SUBJECT: **SFD2402-0064**
SINGLE FAMILY DWELLING

Here are the results of all Inspections located at **15 RED BIRD DR:**

Job	Truss	Truss Type	Qty	Ply	15 Red Bird Drive	166917868
J0324-1425	F2	Floor	3	1	Job Reference (optional)

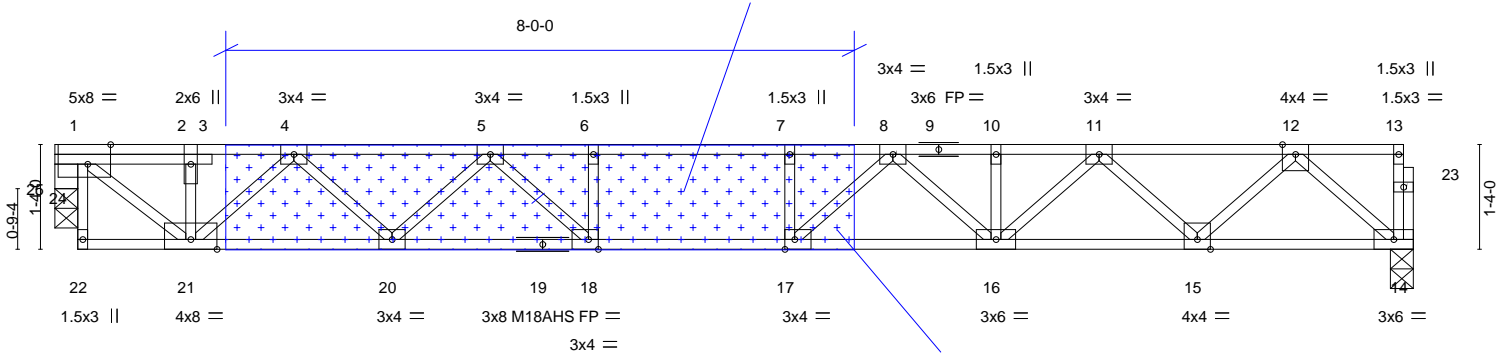
Inspection Type: ROUGH IN
Scheduled Date/Time: 7/1/2024
Completed Date/Time: 7/1/2024
Inspector: Steven Gazlay
Result: DISAPPROVED
Remarks:
Notes: Strap stud straighteners per code. Provide letter for repaired floor truss . Draft stopped top of stairs where furred down ceiling and same area with slanted wall. Strap top plate splices on stairwell wall. Need hurricane clip at joint nine of B3GR. Strap Gables for uplift where required. Attic access not framed. Porch post not installed. Missing 2" square washers on wing walls. Ramset stairwell wall. Mid story strap line set.
